OUT16/4528#35

Camden Medical Campus Precinct (SSD 7387) Comment on the Environmental Impact Statement

**Camden Medical Campus Precinct (SSD 7387)
DPI comment on the Environmental Impact Statement**

Indicative Cross Section for MG1

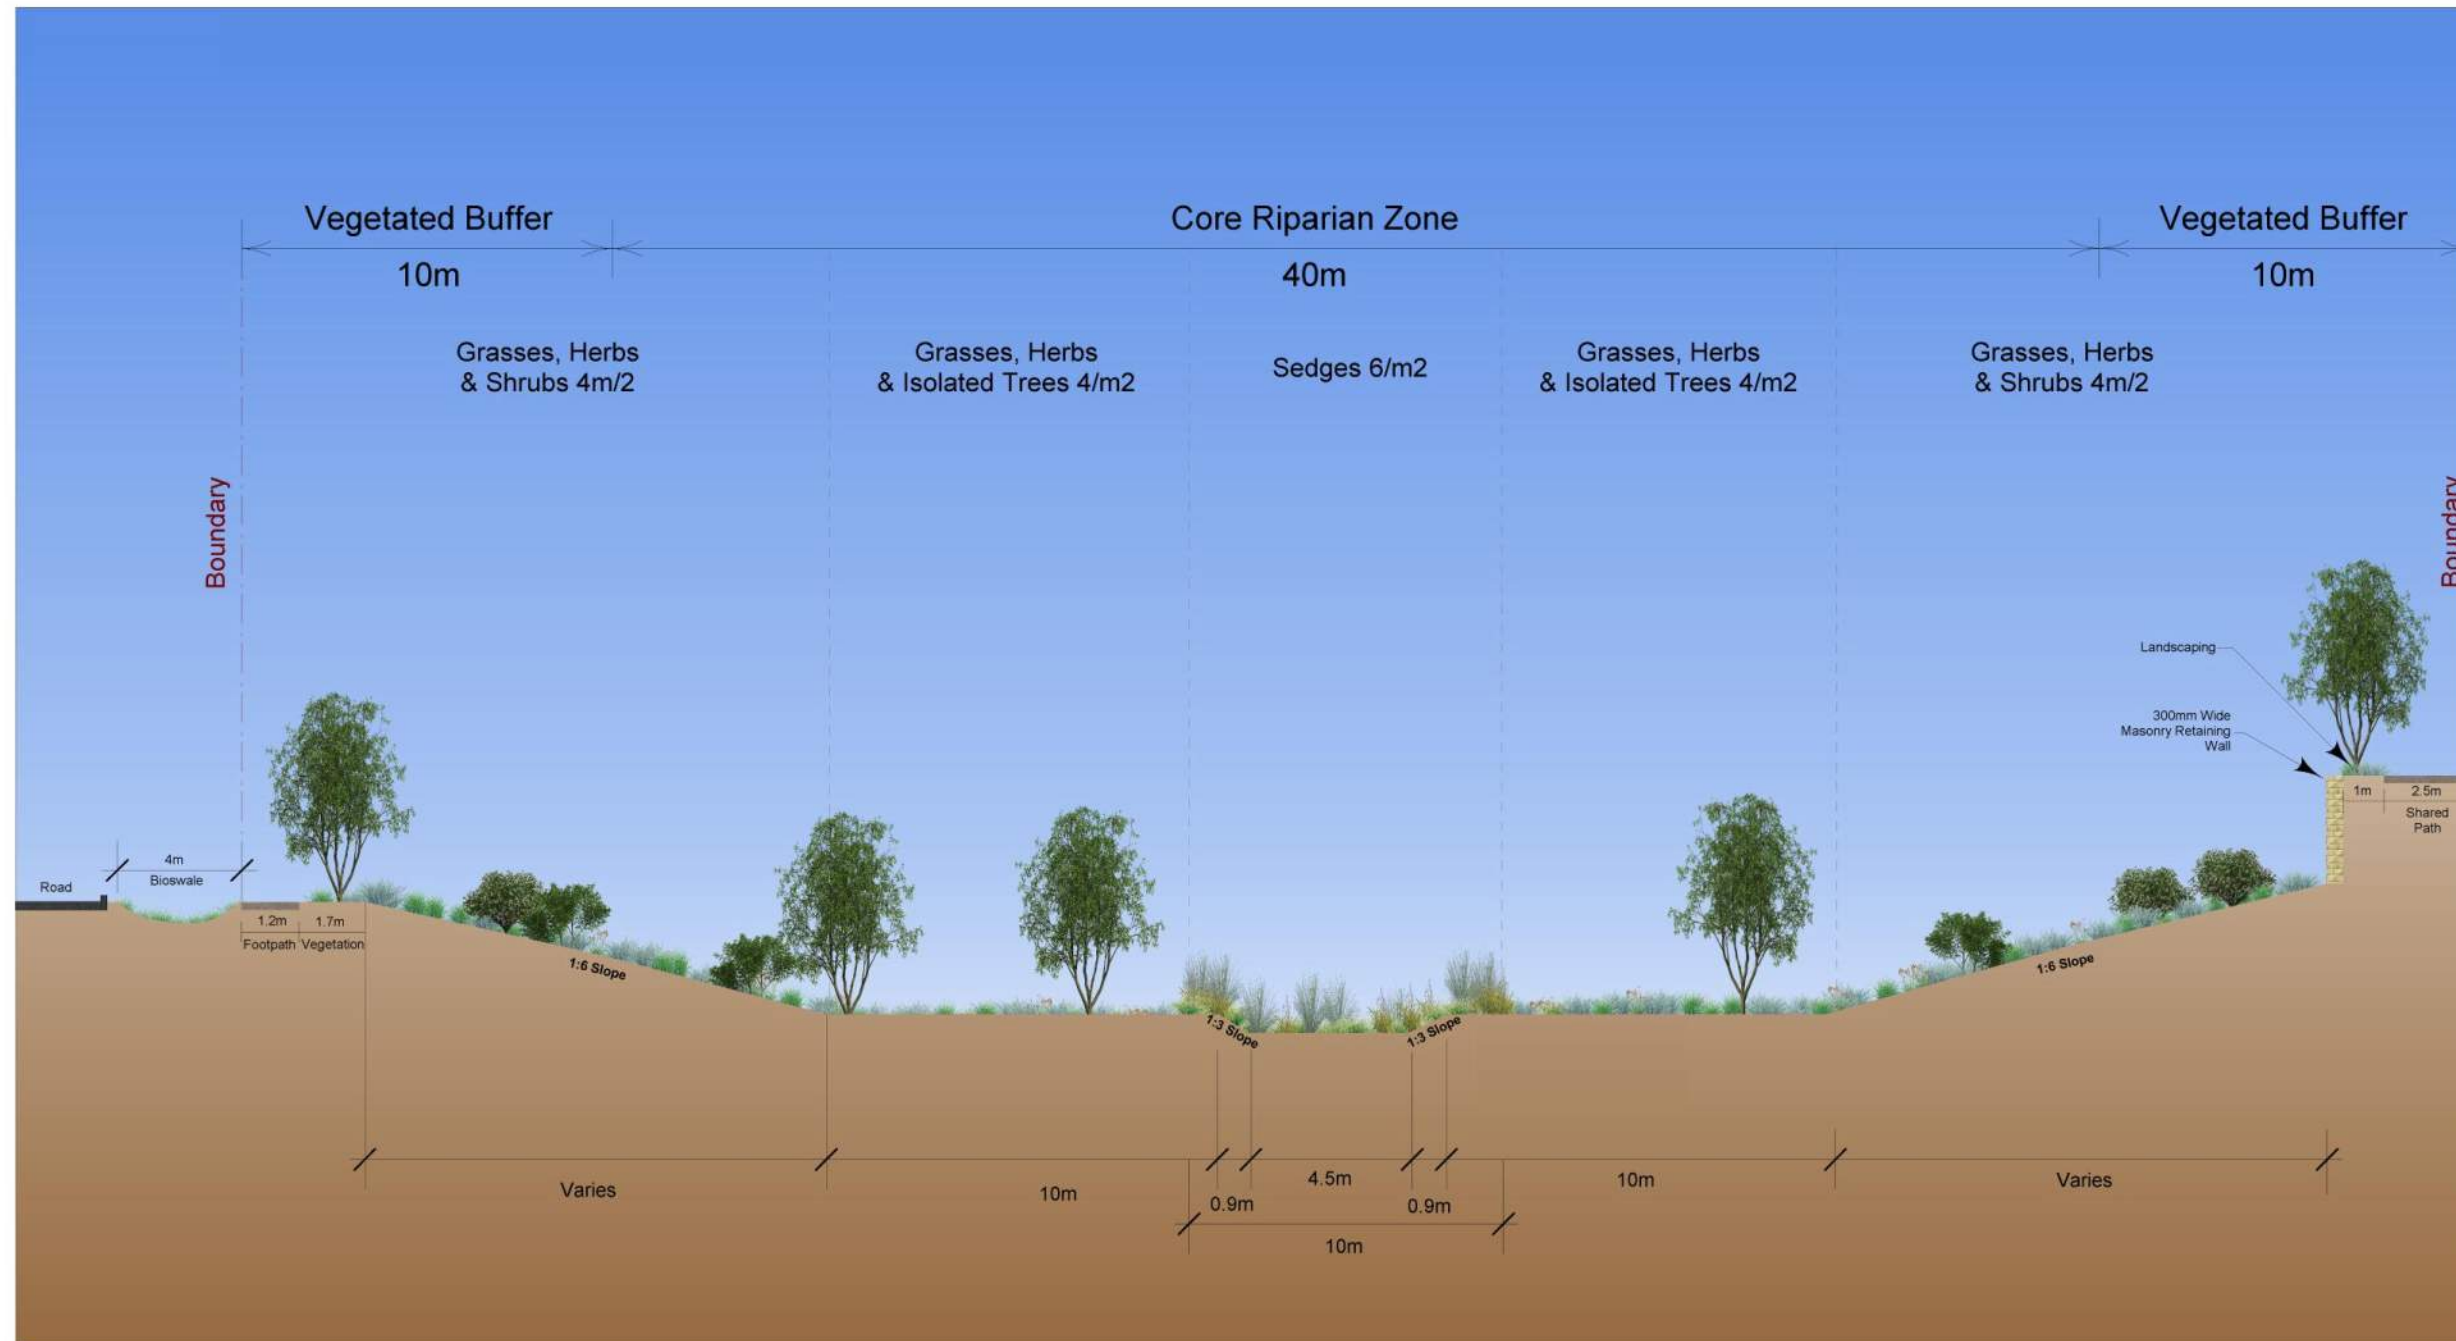
- the amended vegetation management plan (dated 6 November 2015) indicates that Management Zone 1, incorporating the tributary, will be approximately 60 m wide (see Section 3.1.1, page 10);
- the Indicative Cross Section for Management Zone 1 (Appendix 5 of VMP) only shows the total width of the CRZ to be 40 m wide - it has not included the 5 m wide creek in this width;
- the EIS (Section 8.10.2, page 94) and Addendum to the Bushfire Protection Assessment (Appendix 7 to EIS) state the vegetation management plan requires the revegetation along the narrow corridor to be no wider than 10 m on either side of the 5 m wide creek bed which is not consistent with the Category 2 Controls;

The EIS states no asset protection zones are required for the site, however also notes the vegetation management plan has been changed so that the corridor will be vegetated such that it does not constitute bush fire prone vegetation (Section 8.10.1, page 94), while the VMP proposes to vegetate the riparian corridor (including the CRZ) so it is not a bushfire hazard (see Appendix 5 of the VMP– indicative cross section for Management Zone 1). This

appears consistent with an asset protection zone. The proponent should clarify whether any asset protection zone is required for the site, and ensure the project is consistent with requirements by ensuring that any such zone is not located within the riparian protection area, with revegetation of the CRZ in particular consistent with a density that would occur naturally.

- 1) The proponent should demonstrate the proposed riparian protection area in Management Zone 1 is consistent with the requirements of the [Oran Park and Turner Road Waterfront Land Strategy 2009](#). Specifically, the restored and rehabilitated riparian protection area should comprise:

- a) a core riparian zone of an average of 40 metres (20 metres either side of the watercourse) measured from the top of the bank,
 - b) the width of the watercourse itself, and

- c) a 10 metre vegetated buffer either side of the core riparian zone;
- 2) Revegetation should be undertaken using local provenance vegetation, with the core riparian zone revegetated to a density that would occur naturally; and
